Application No: AB/135/20/OUT
Site Address: Land at Ford Road Arundel
Description of works: Outline application with some matters reserved (except for access) for the development of 90 dwellings & associated amenity land. This application is a Departure from the Development Plan, affects the setting of listed buildings & affects the character & appearance of the Arundel Conservation Area.

Thank you for your internet representation made on 18th January 2021 which has been recorded as an objection with the comments as follows:

Parameter Plans

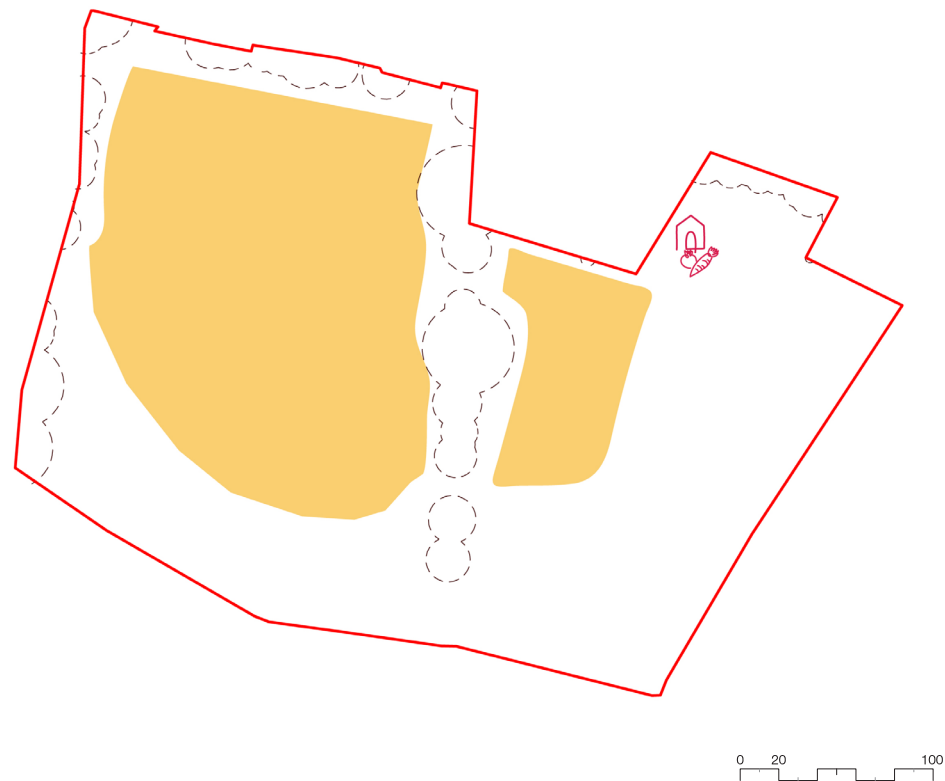
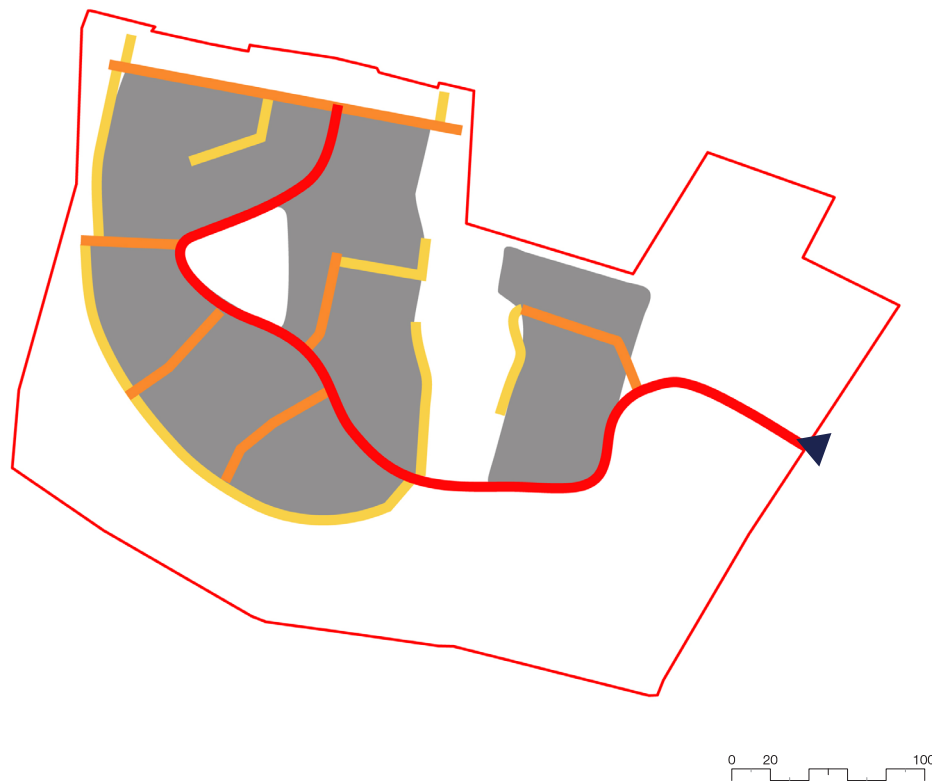
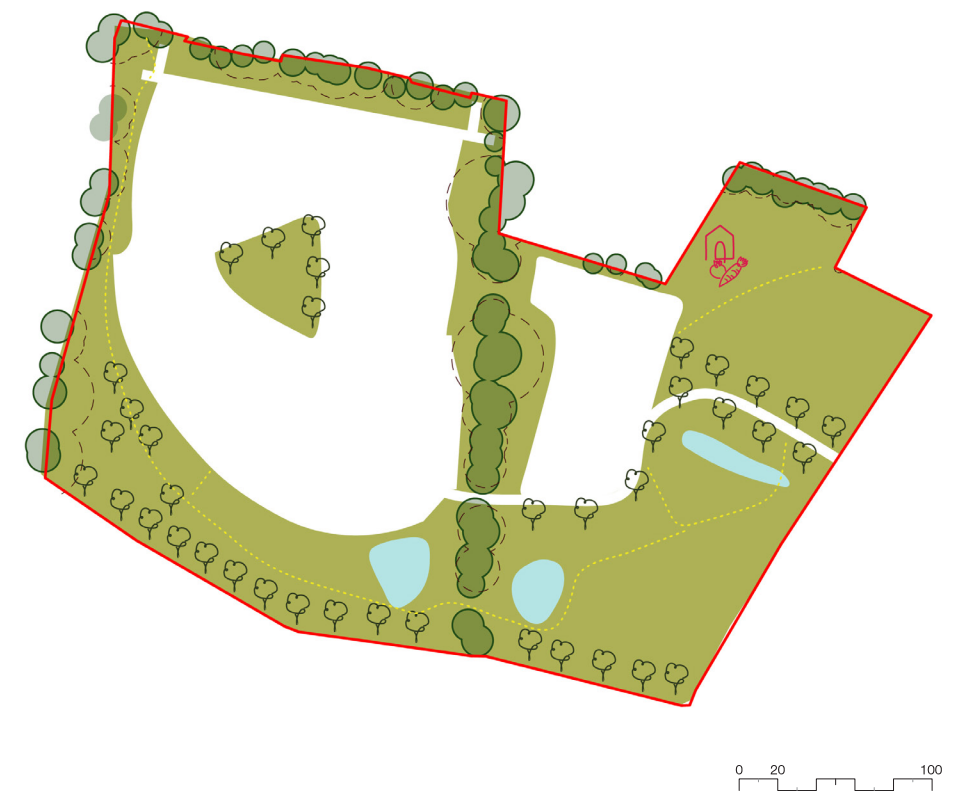
The masterplan included with this planning application is inaccurate. It shows more than 90 residential units and does not show the connection to Dalloway Rd as an emergency exit only.
